Our Ref: BR/25/21/DOC

Town & Country Planning Act 1990 (as amended)
Town and Country Planning (Development Management Procedure) (England) Order 2015
Approval of details reserved by condition imposed under ref BR/257/19/PL relating to Condition No 4 -
balcony railings (height, finish, manufacturer/model name)
The Royal Hotel The Esplanade Bognor Regis PO21 1SZ

Arun District Council have decided to **APPROVE details reserved by this condition**

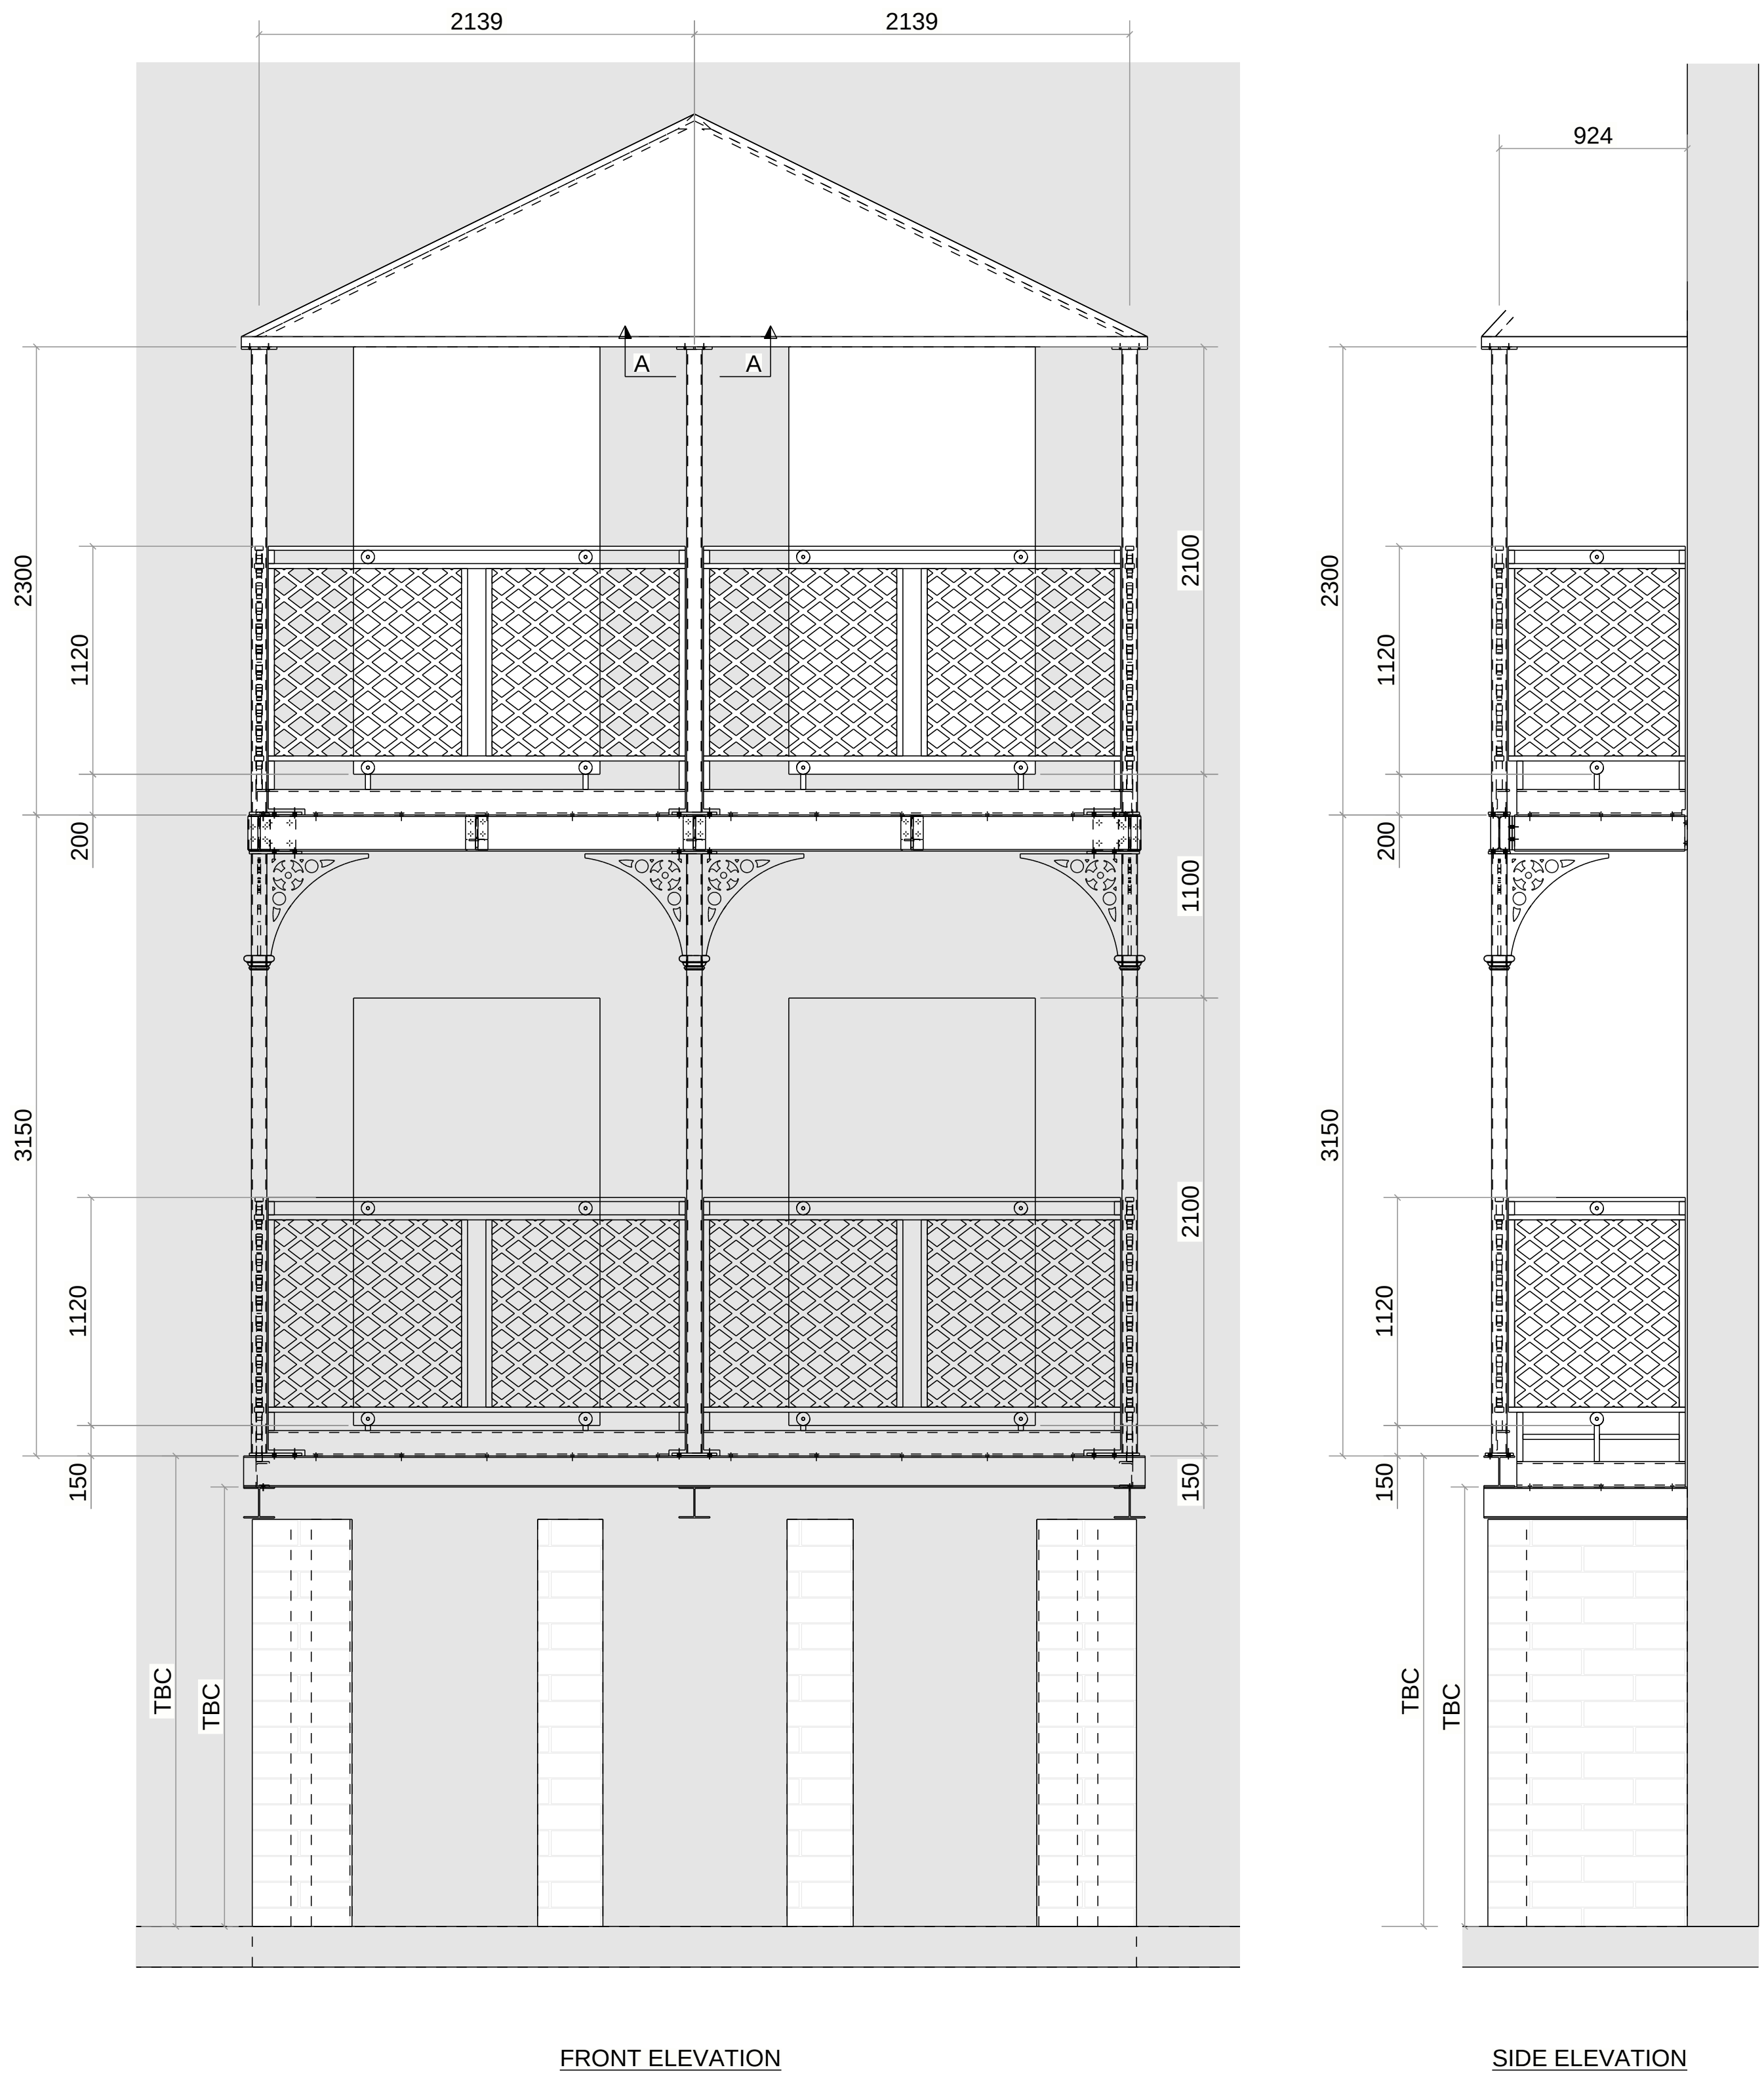
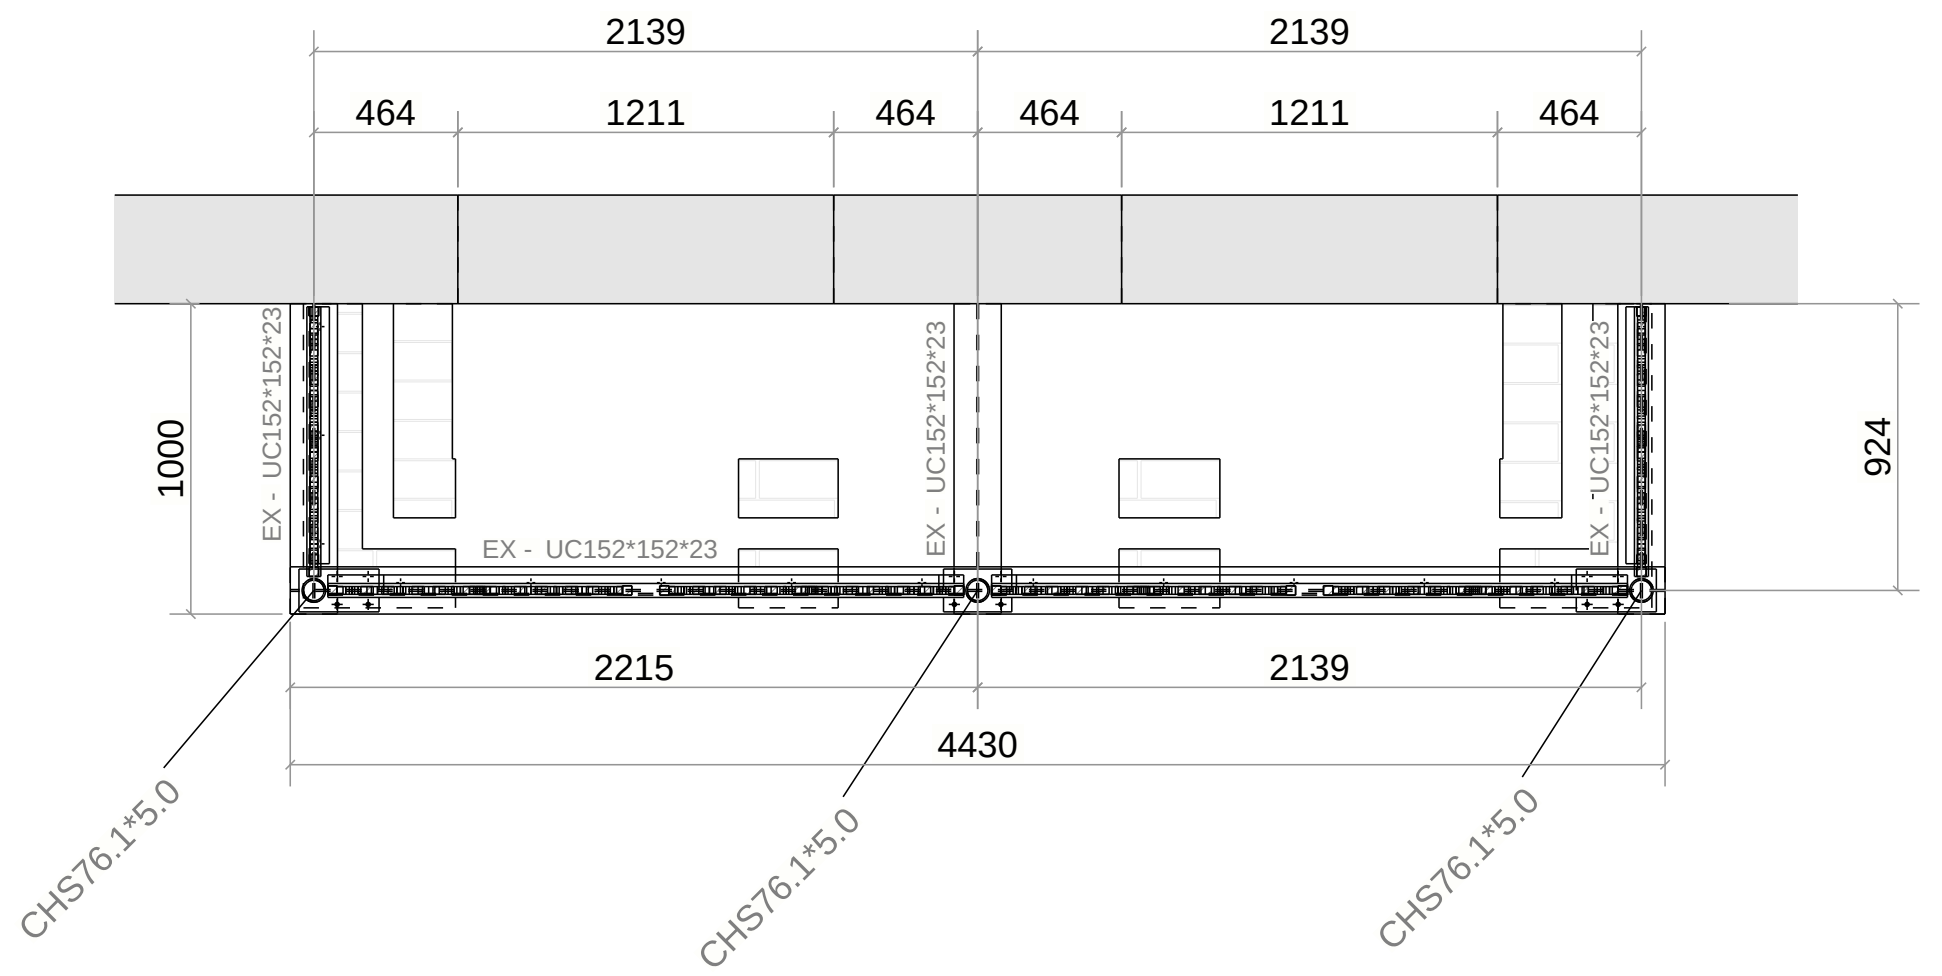
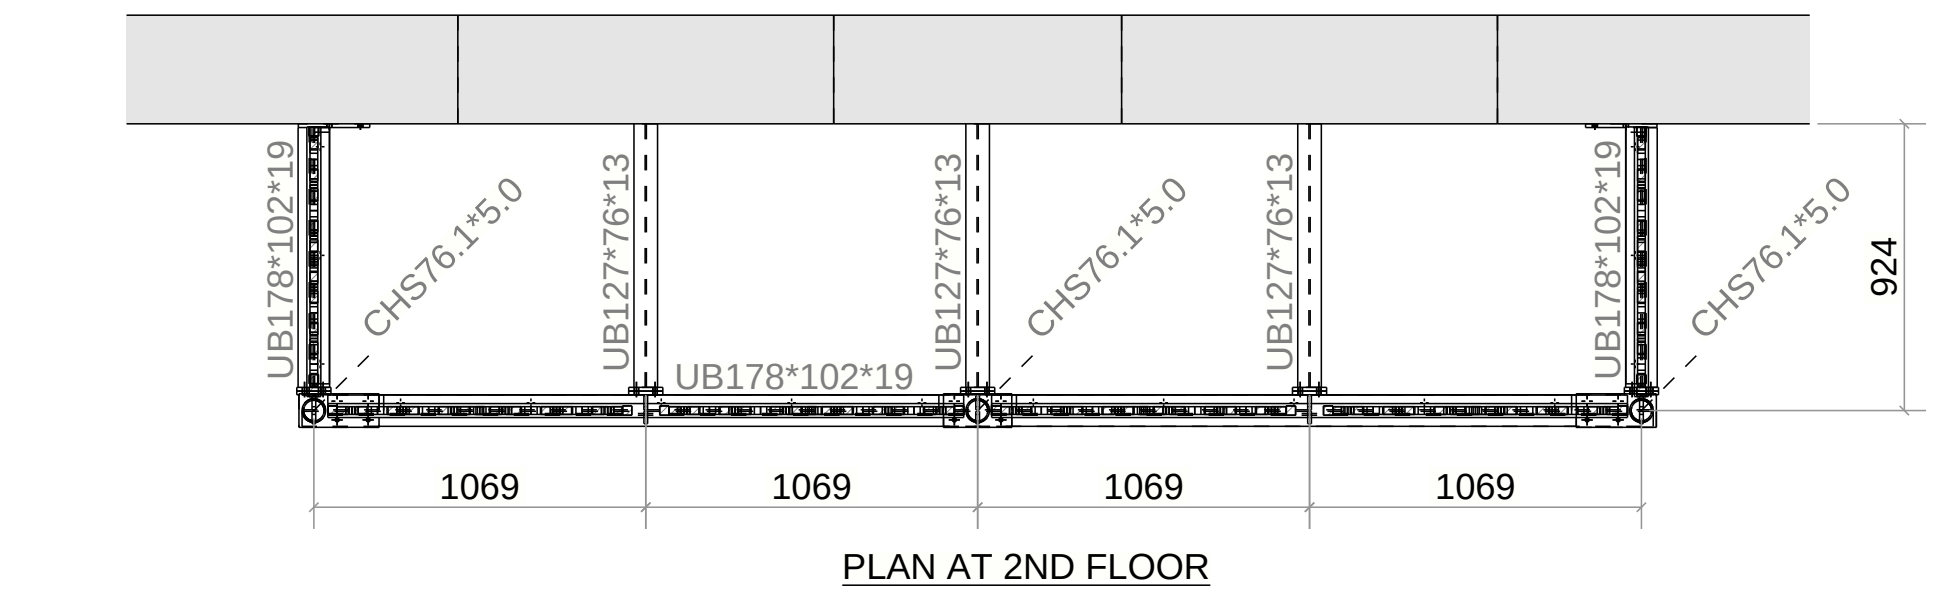
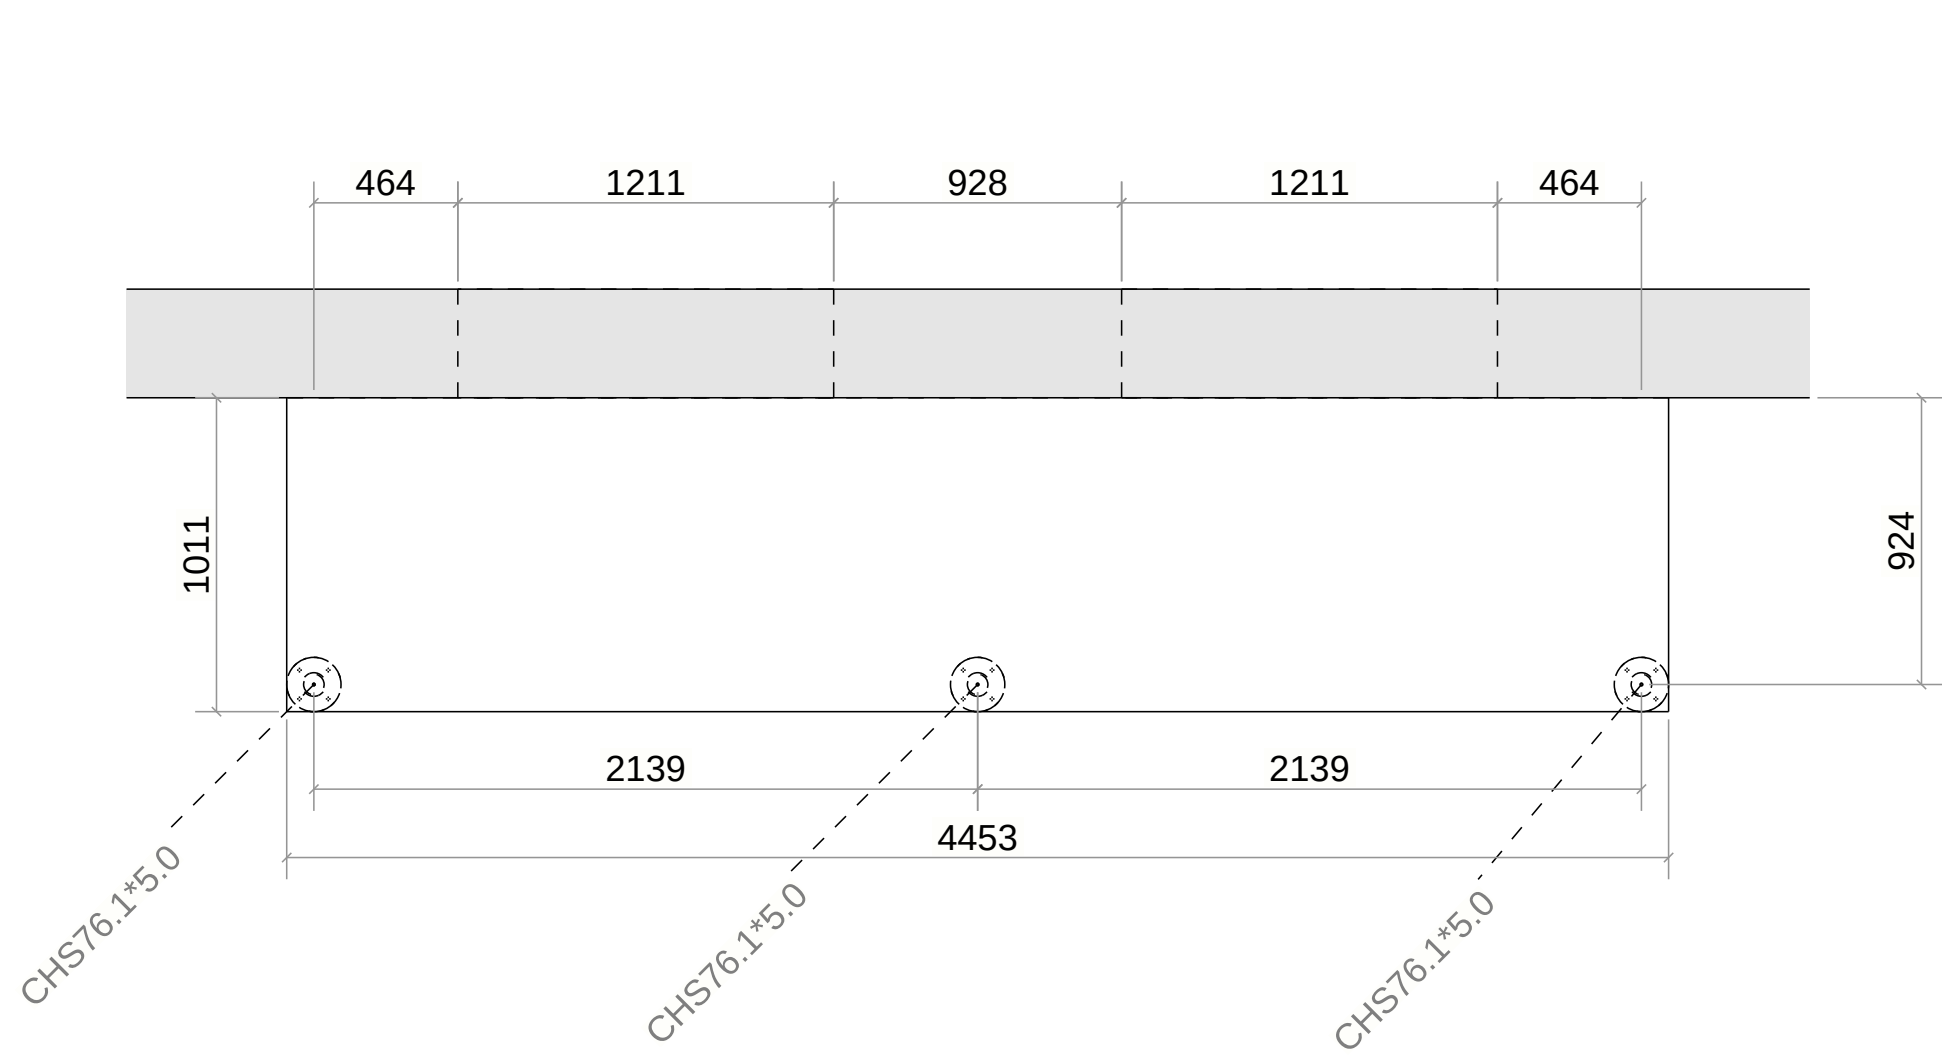
Type 4 - New Metalwork, proposed height 1120mm, black painted, Bespoke railing produced by Alpine Group, drawing "S4068-GA-001" and "S4068-GA- 002".
